An Coimisiún Pleanála,
64 Marlborough Street,
Dublin 1,
D01 V902

Planning Authority Reference Number: 2360027
Your Case Number: PL02.319457

Re: Further Information Response – Proposed 20-Year Quarry Development at Ardkill More and Drumcrow Townlands, Carrickaboy, Co. Cavan

PLANNING REFERENCE - 647325

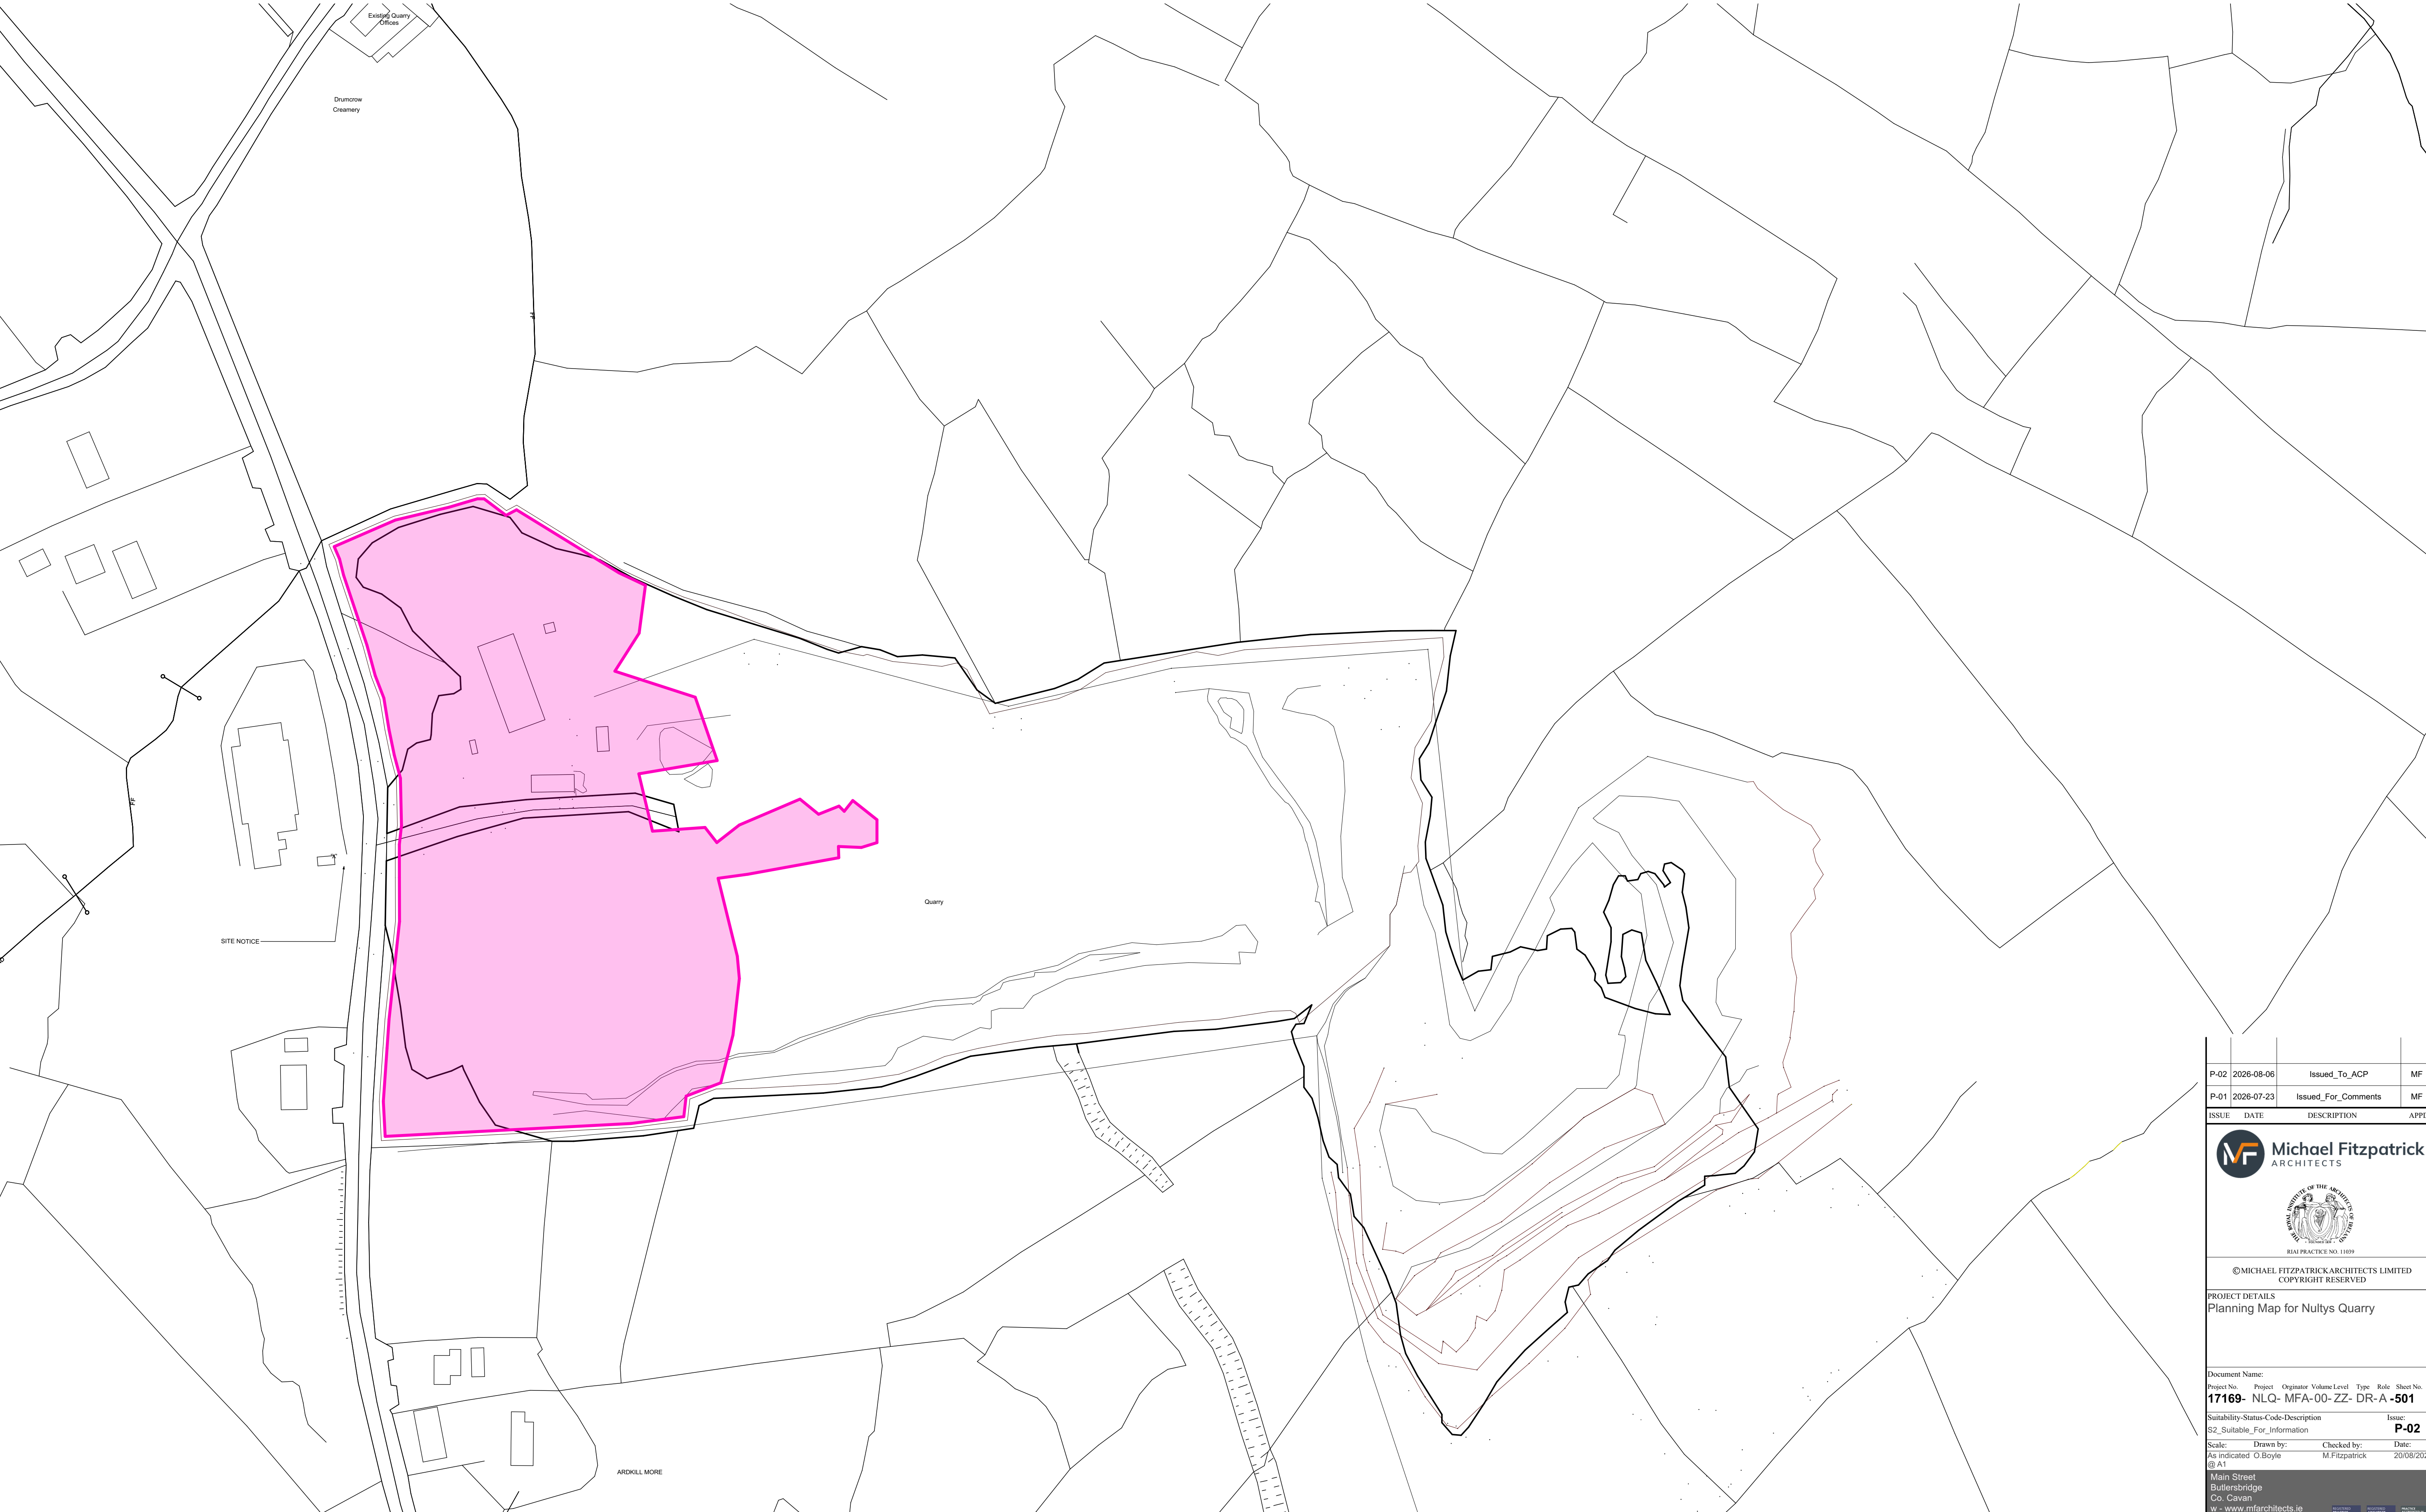
- i) Details of the planning history and permitted lifespan of the quarry including the following:
 - a. A copy of the decision issued under PA Ref: 7325.

See attached drawings from planning file from Cavan County Council. For the ease and clarity these drawings have been updated by Michael Fitzpatrick architects and a copy of the relevant permitted area is shown on the attached drawing No. 17169-NLQ-MFA-00-ZZ-DRA-A-501.

Overall Site Plan - Proposed

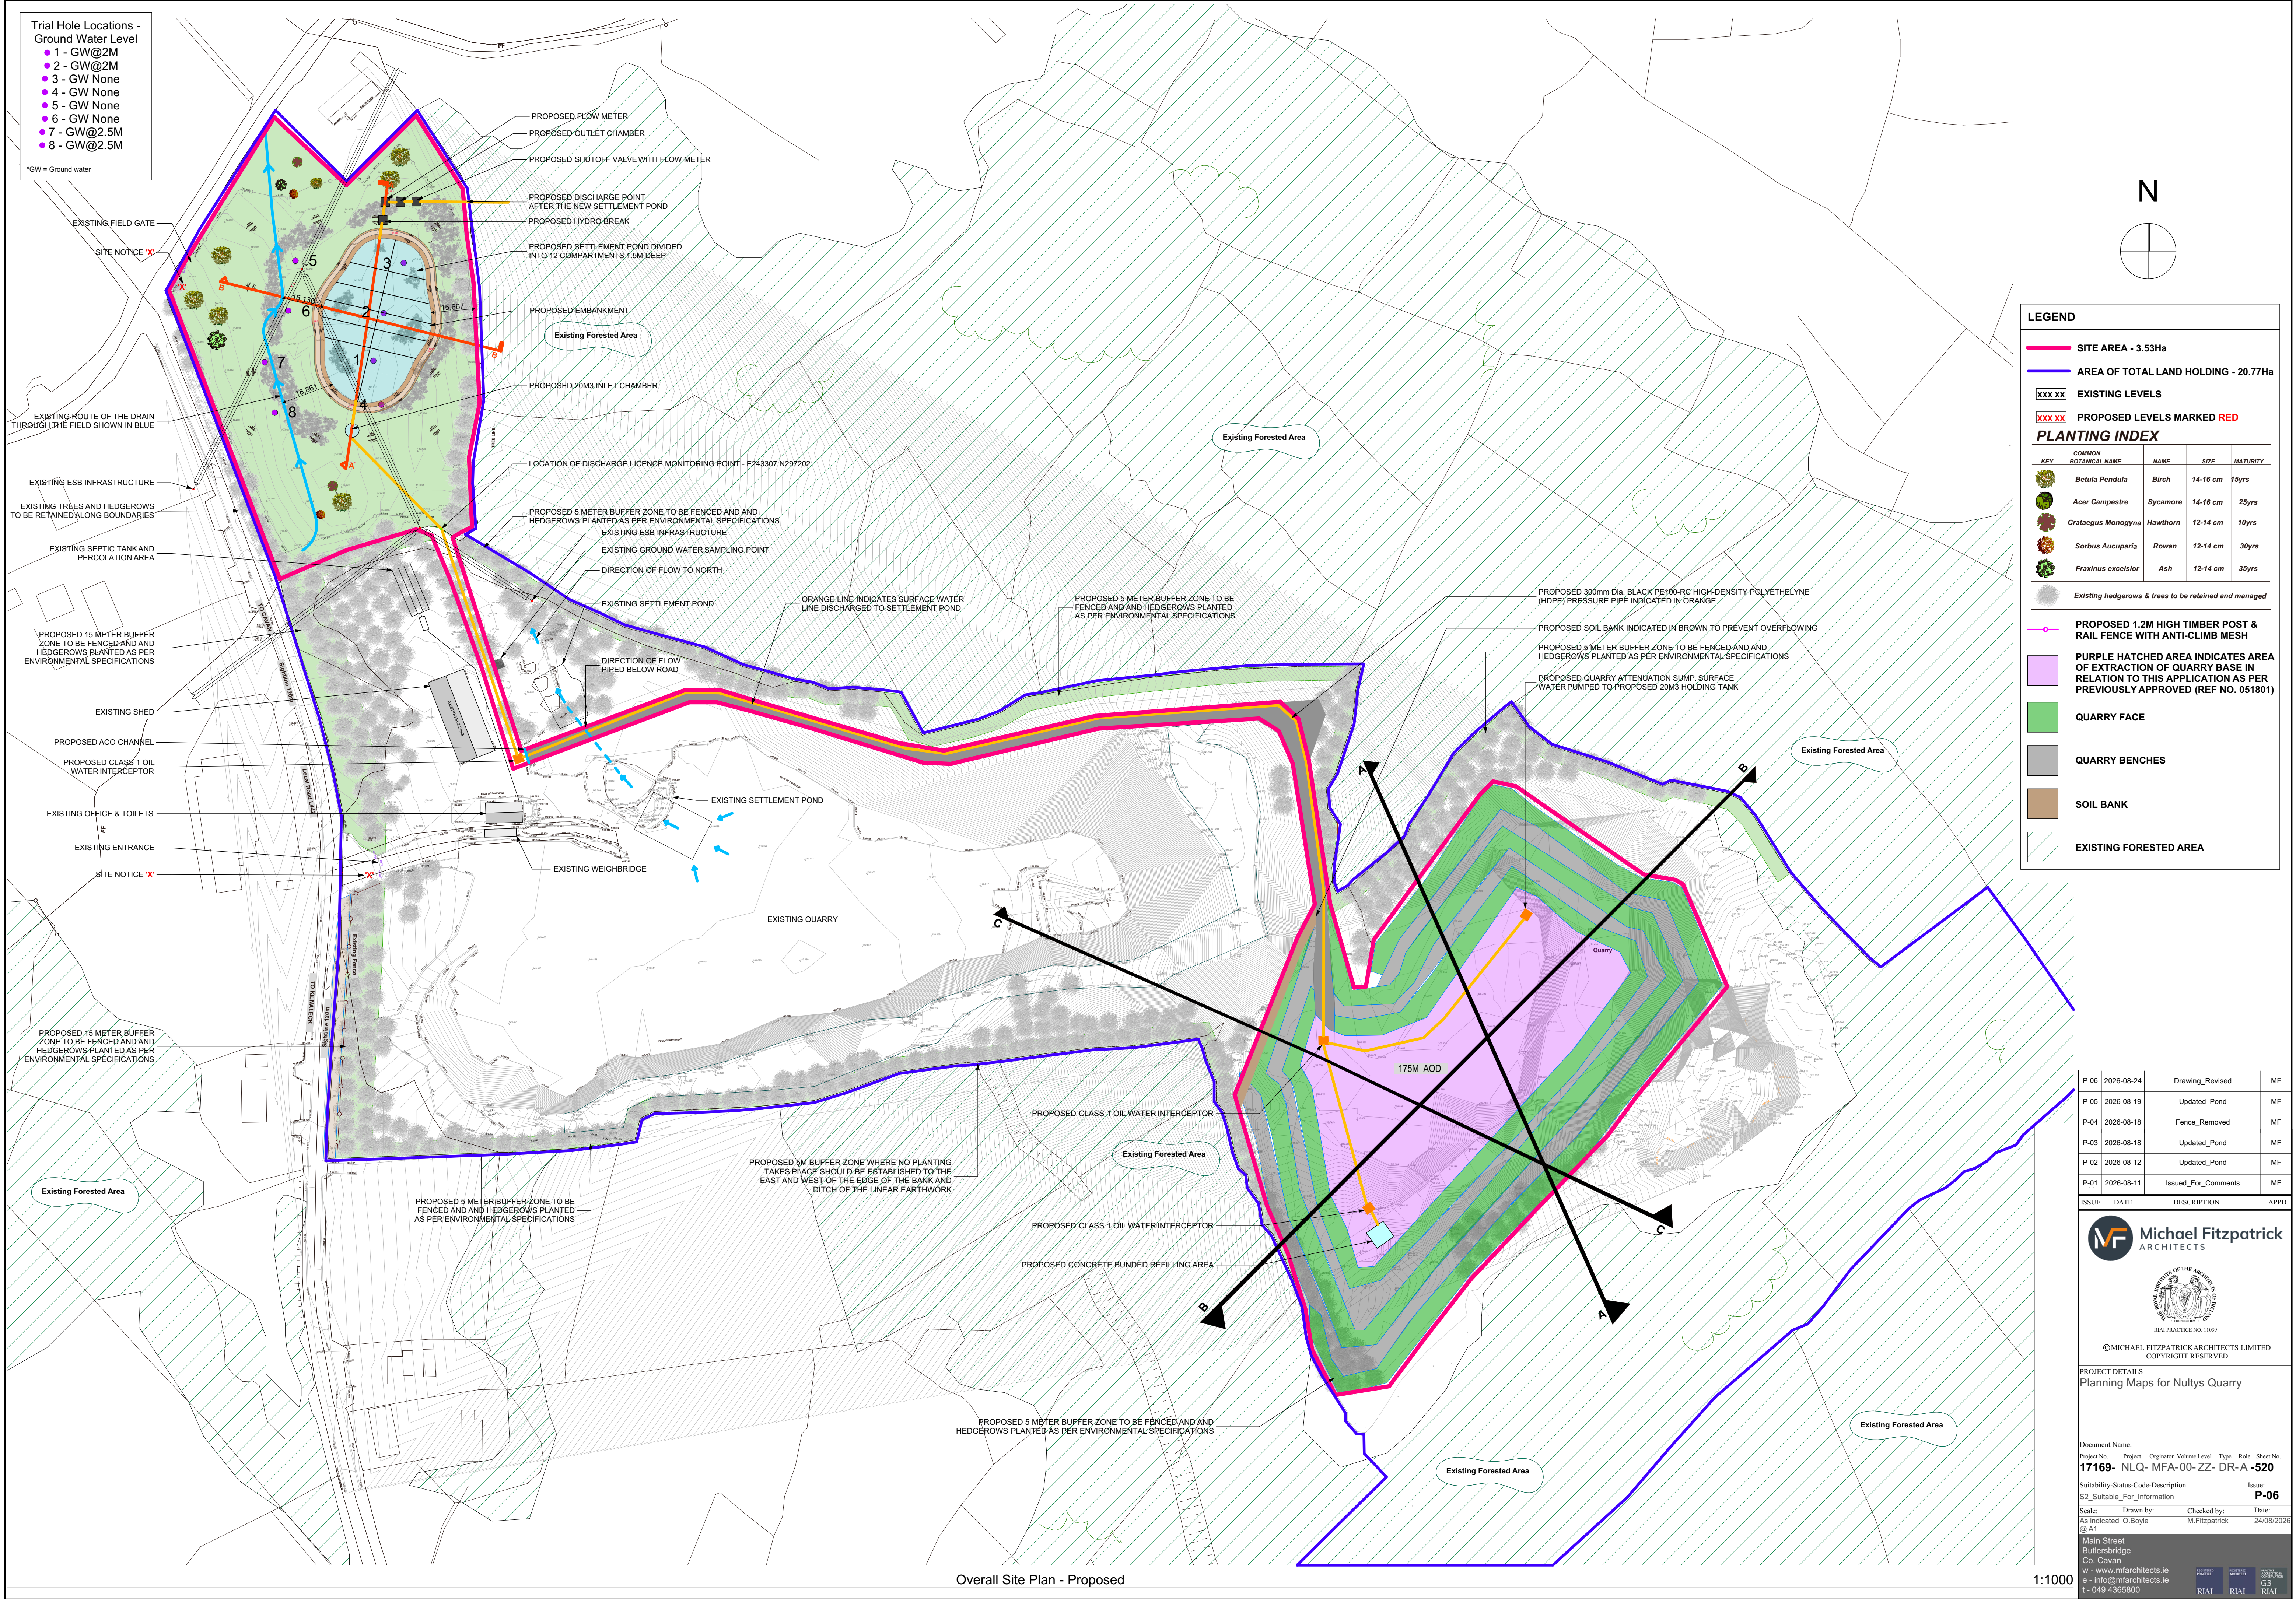
- (i) A revised Site Layout Plan which illustrates the location of existing settlement ponds serving the QY7 quarry.

A revised Site Layout Plan is attached which clearly identifies the location and extent of the existing settlement ponds serving the QY7 quarry, together with the relevant existing and proposed surface water drainage infrastructure.

For clarity, the existing settlement ponds will continue to serve surface water runoff arising from the existing QY7 quarry only. They will not receive surface water runoff from the proposed development.

The proposed development will be served by a separate surface water management system incorporating the proposed new settlement pond and associated collection, treatment, attenuation and discharge infrastructure.

Pond Section A-A

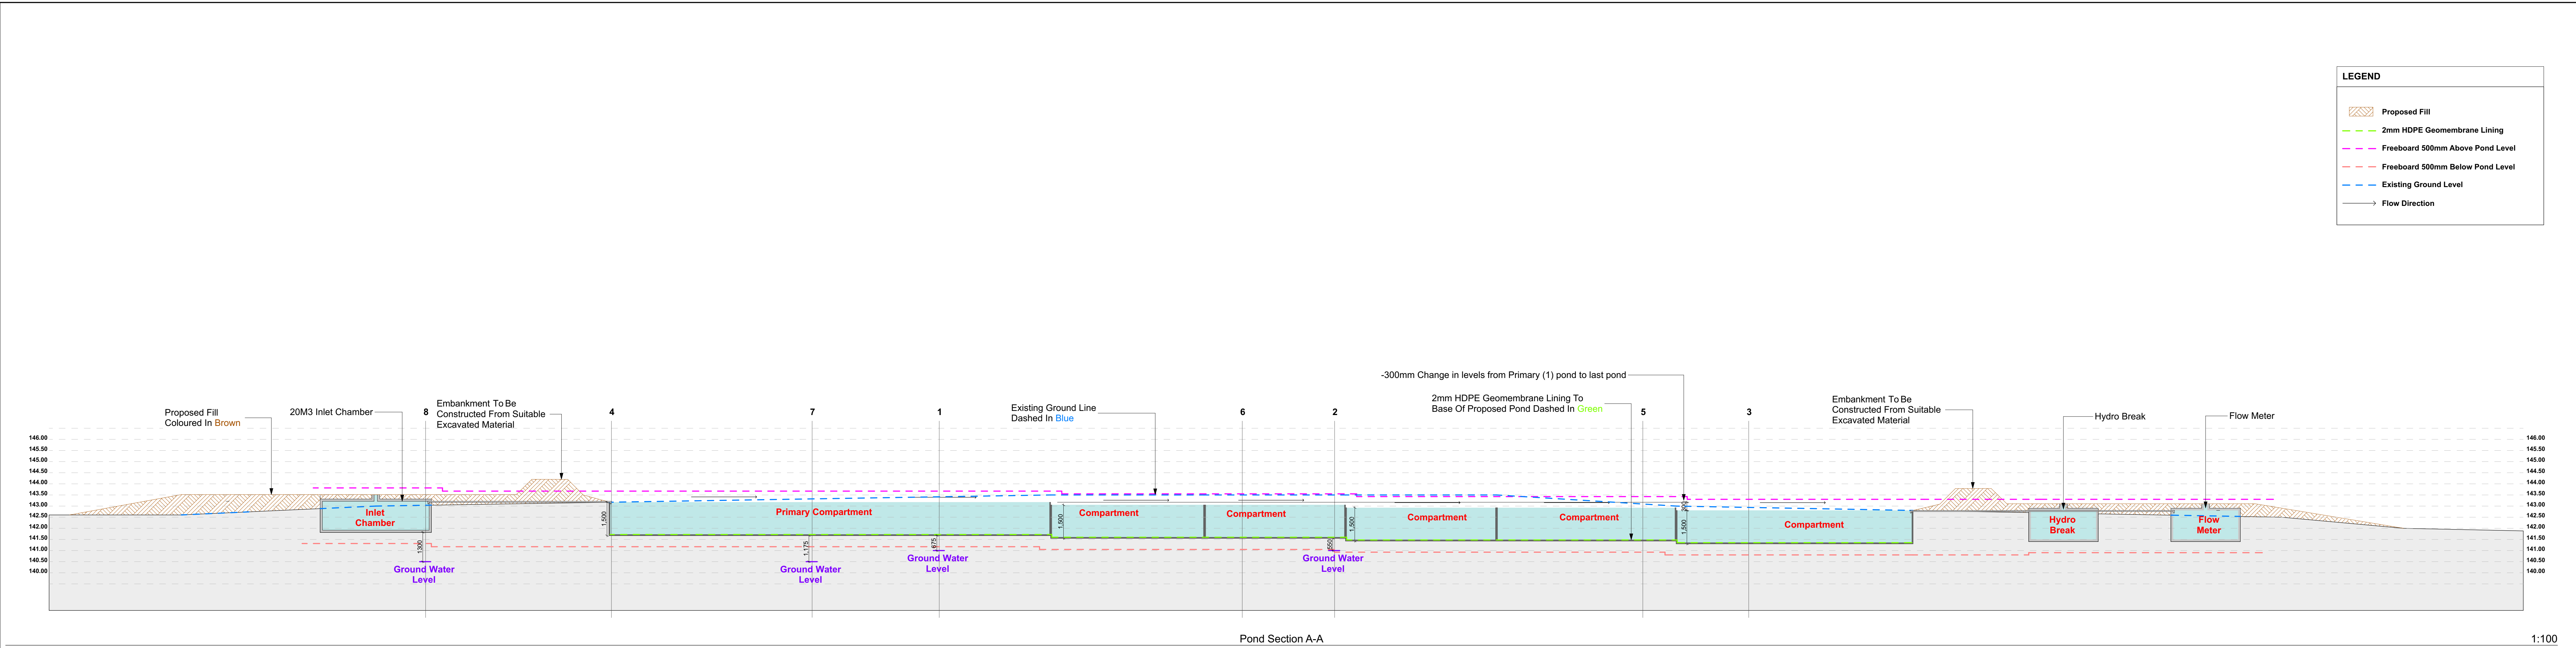
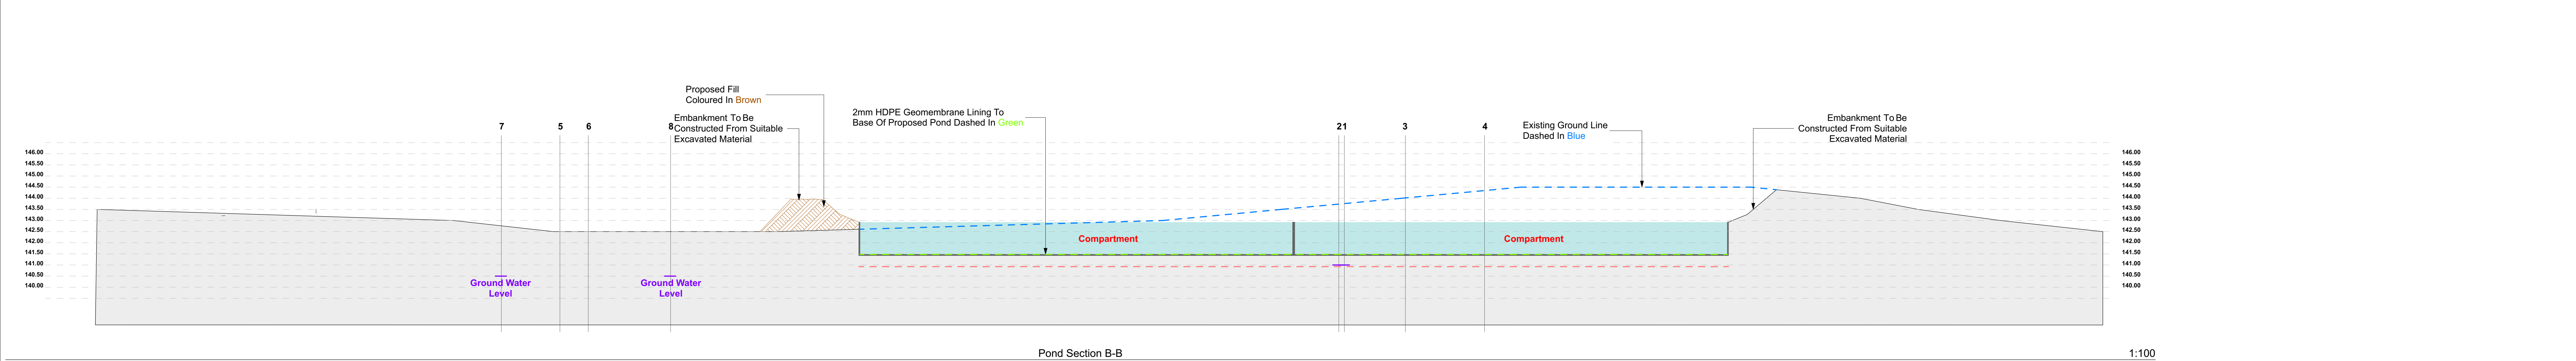
- (i) Revised drawings of the greenfield site to the north of the appeal site within the proposed settlement pond area which details existing site levels and illustrates existing features on site including water/drainage features and existing ESB infrastructure. You are required to provide an assessment of the impact of the proposed development on same.**
- (ii) Revised Drawing no. TE23.011.200 (Settlement Pond Detail) which illustrates the existing groundwater levels within the proposed settlement pond area which demonstrates the actual freeboard between the base of the proposed settlement pond and the established groundwater level in the area.**

(ii) Revised drawings and associated sections are attached showing the existing groundwater levels established within the proposed settlement pond area from the trial-hole investigations. The drawings demonstrate the relationship between the proposed settlement pond base and the established groundwater levels and identify the available groundwater freeboard across the pond area. The minimum freeboard between the proposed settlement pond base and the established groundwater level is a minimum of 0.5m.

Having regard to the identified land drain, the revised settlement pond layout provides a minimum separation distance of 10 m between the drain and the proposed settlement pond.
